Cc: Re: notice of Response to Submissions Report for the Australian Technology Park – Precinct Marker Signage
Subject: Strategy (SSD-7317-Mod-19).
Date: Friday, 2 October 2020 4:22:46 PM

Thank you for considering my final comments. They relate to the proposed Central Avenue signage (location 2 closer to Garden Street), in particular the location of the digital screen.

Location Plan – Central Avenue

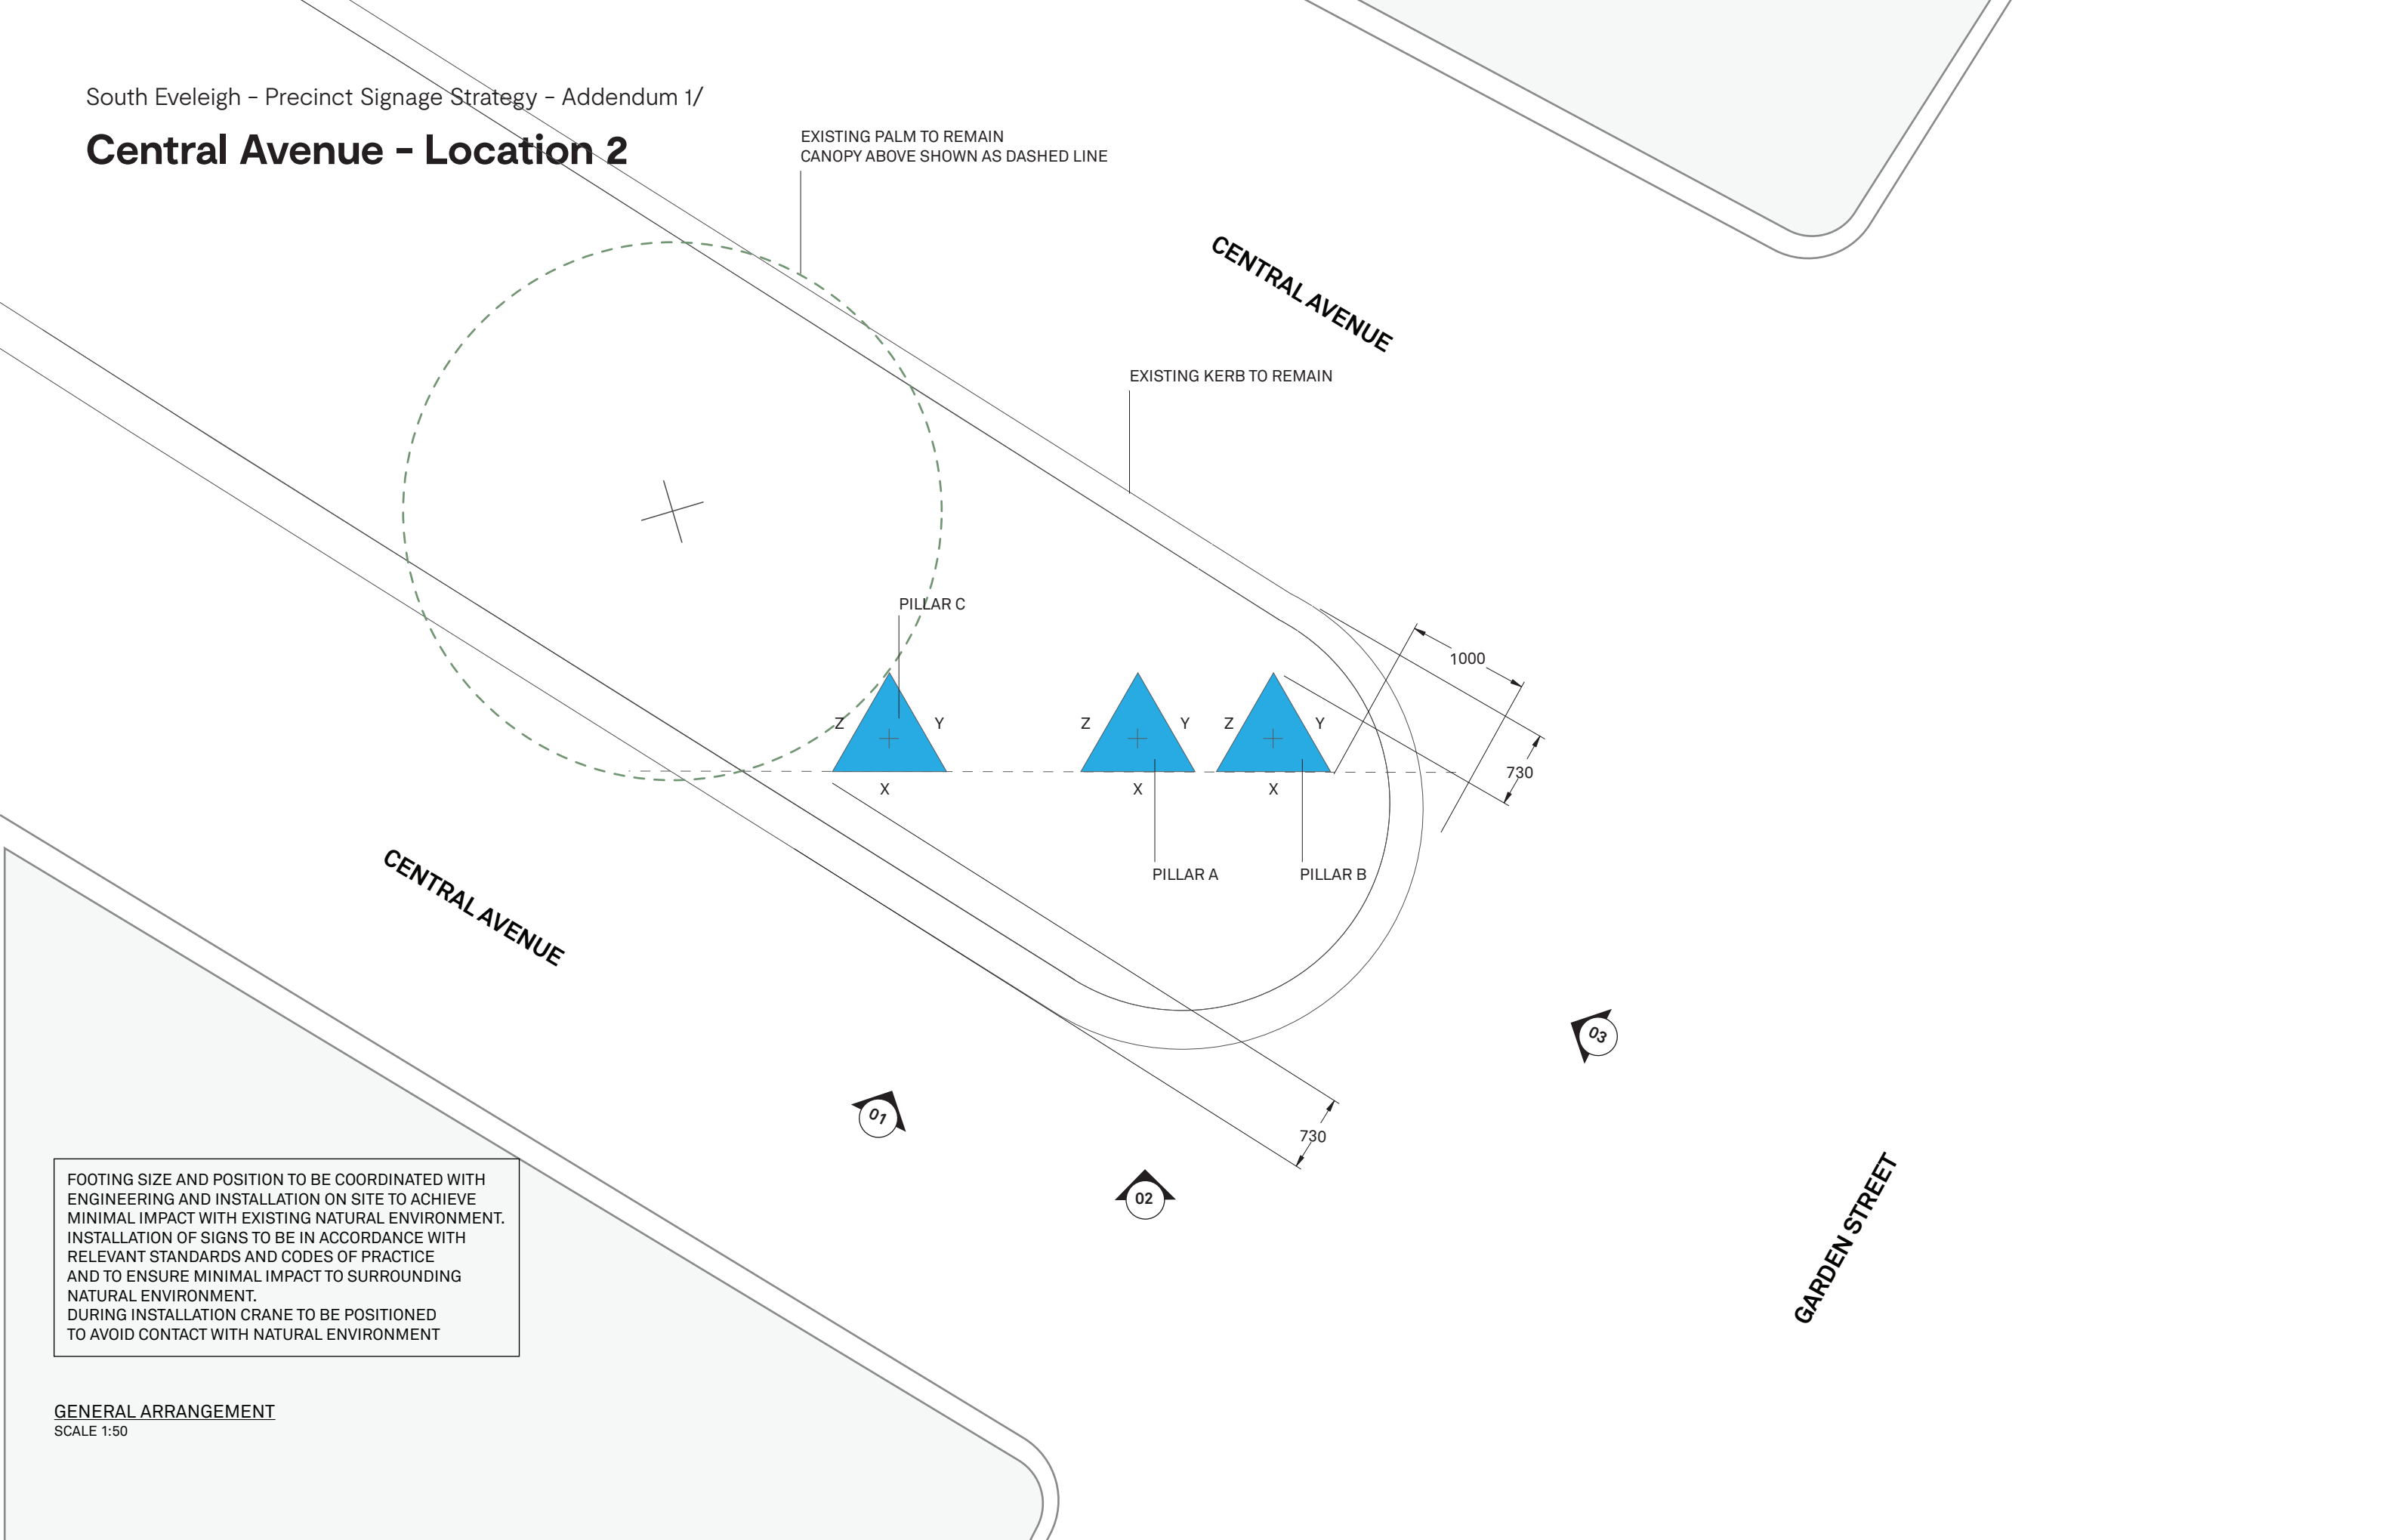
But I do feel strongly and wish to personally state my strong objection to the specific location of the proposed digital screen at Location 2.

1. The Central Avenue/Garden Street Entry point is not the acknowledged Main entrance of the precinct. Davy Road is.
2. All the arguments provided for not locating the digital screen at the Main entrance, i.e. in Davy Road, are, to my knowledge, incorrect.

Hence my proposal for a more internal sign, but still very close to the main entrance at Davy Road.
